Consultee Comments for Planning Application

SDNP/24/01292/FUL

Address: The Oaks 35 St Marys Road Liss Hampshire GU33 7AH

Proposal: Detached dwelling

4 Elevation D Scale: 1:50

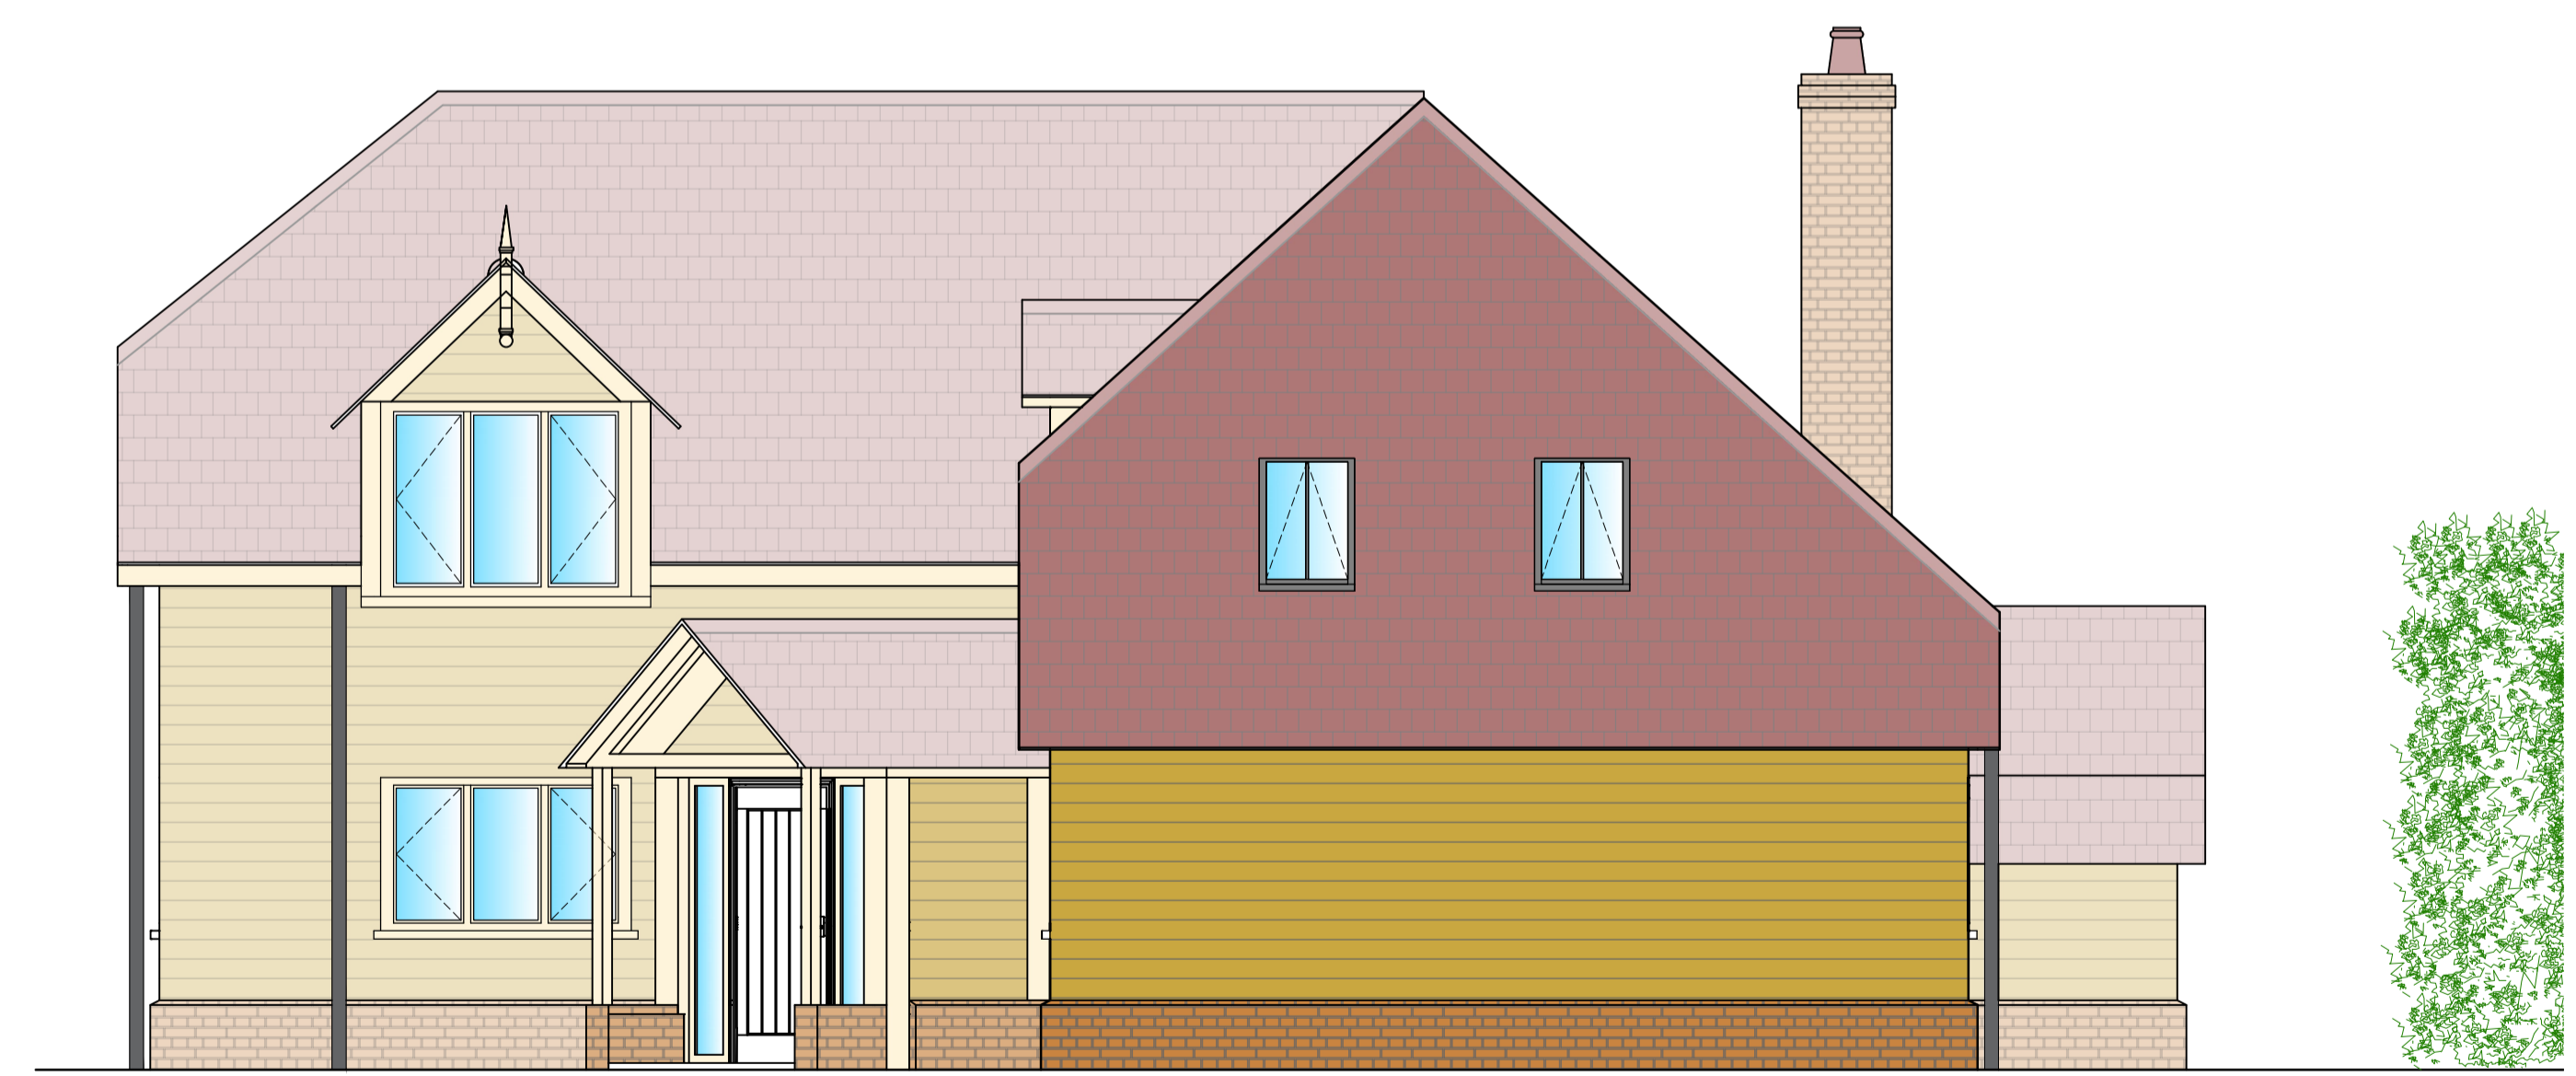
I welcome the statement about ASHP and PV panels but I cannot see them on the elevations.
